DEPARTMENT OF PARKS AND COMMUNITY SERVICES

Subject: Meadowlake Industrial Park Preliminary Plan, 2nd Submittal - (SP-23-006)

The Park Planning Division of the Parks and Community Services Department has reviewed the 2nd submittal of the Meadowlake Industrial Park Preliminary Plan and has the following additional comments of behalf of El Paso County Parks:

PRELIMINARY ENLARGED SITE PLAN

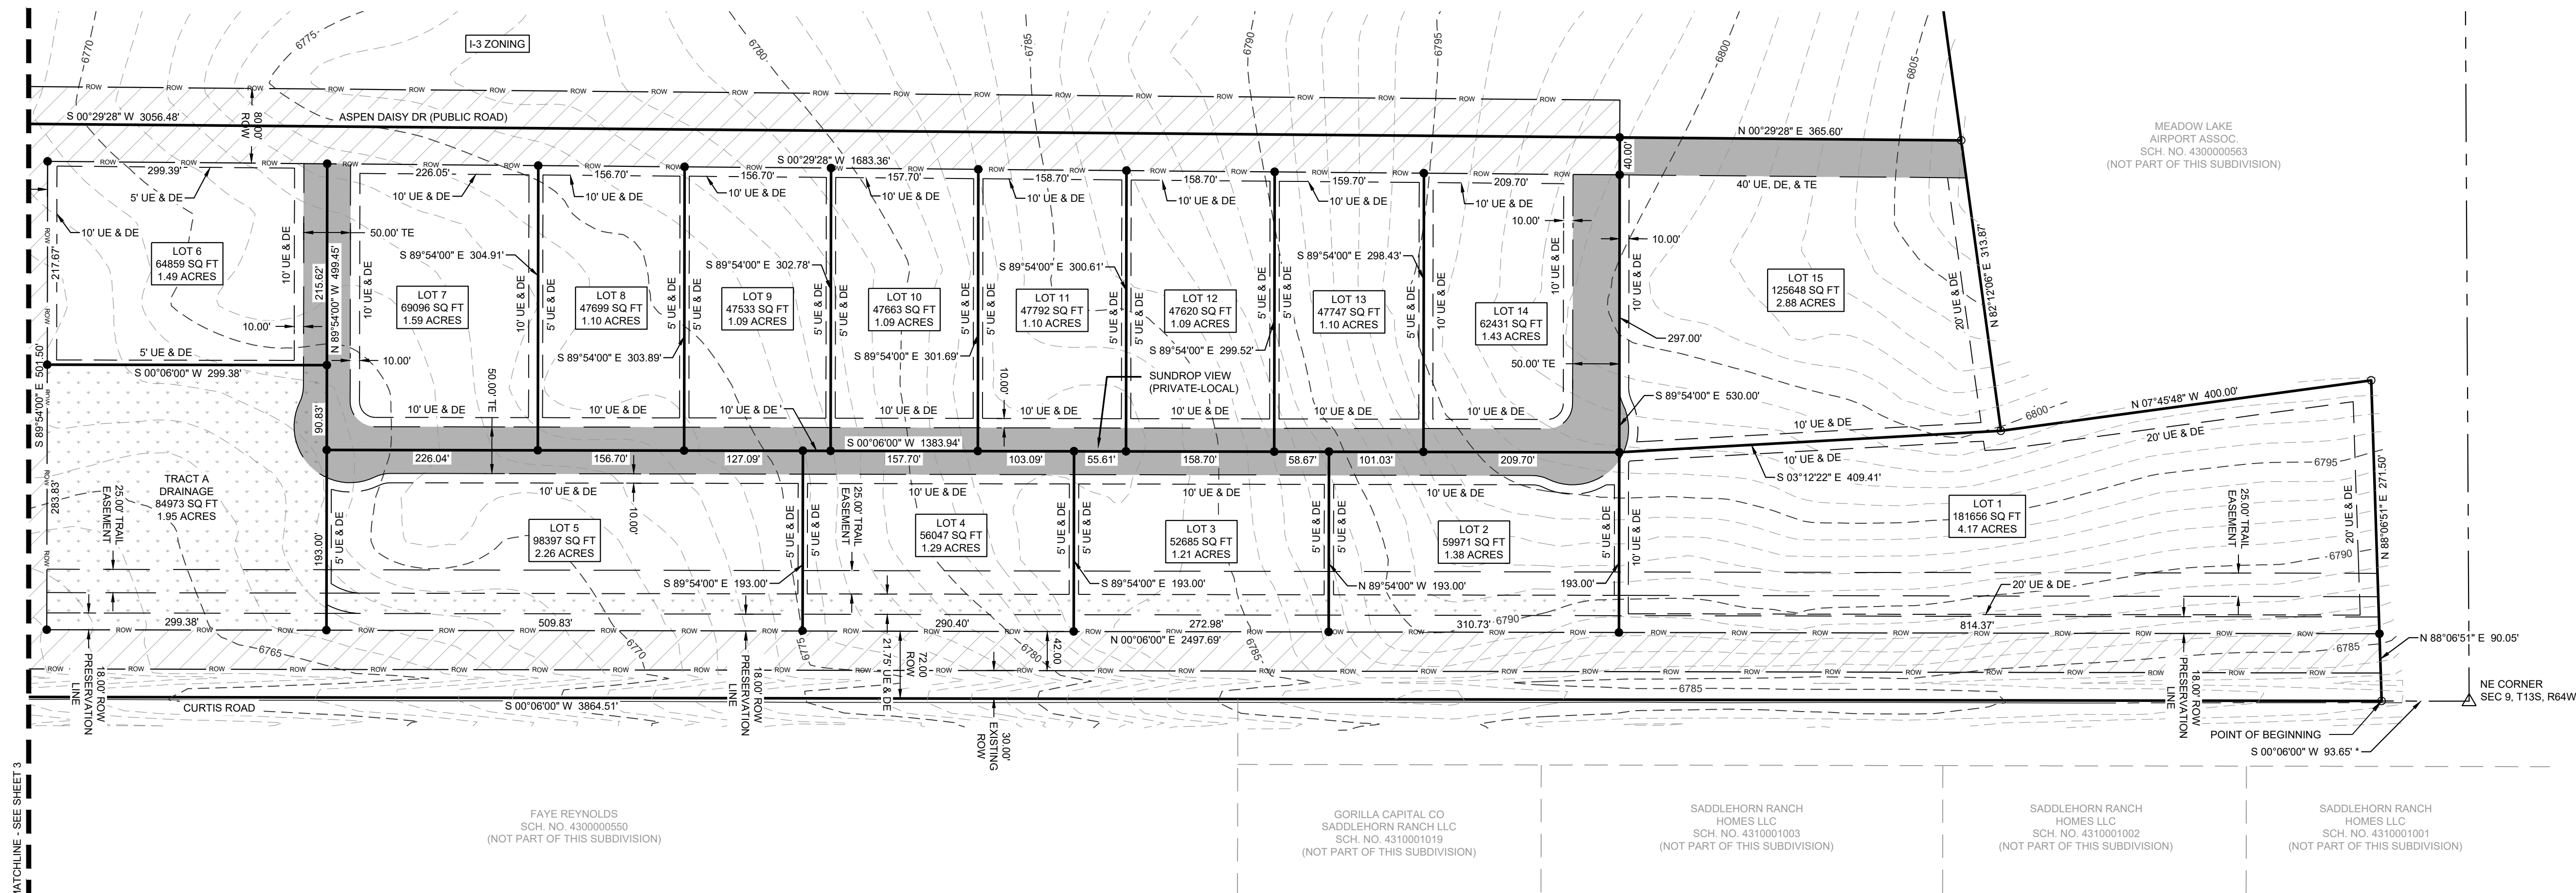
Staff acknowledges and is encouraged by the inclusion of the 25' public regional trail easement on the Preliminary Plan, particularly its location outside of the existing Curtis Road right-of-way. On pages 3 and 4 of the Preliminary Plan, the trail easement is shown located adjacent to the right-of-way, but partially overlapped by the adjacent drainage easement and right-of-way preservation area. The trail easement cannot be collocated with either the drainage easement or ROW preservation area, as (1) the trail, when constructed, must be buildable and not located in a drainage structure or on unbuildable terrain, and (2) a trail easement cannot be located within a ROW, as future road construction could negatively impact the trail corridor. As such, staff recommends that the trail easement be located outside of both the drainage easement and ROW preservation area. If the ROW preservation area is to never be used for future right-of-way, staff will consider the trail easement location within the preservation area. El Paso County Public Works staff will need to verify this scenario.
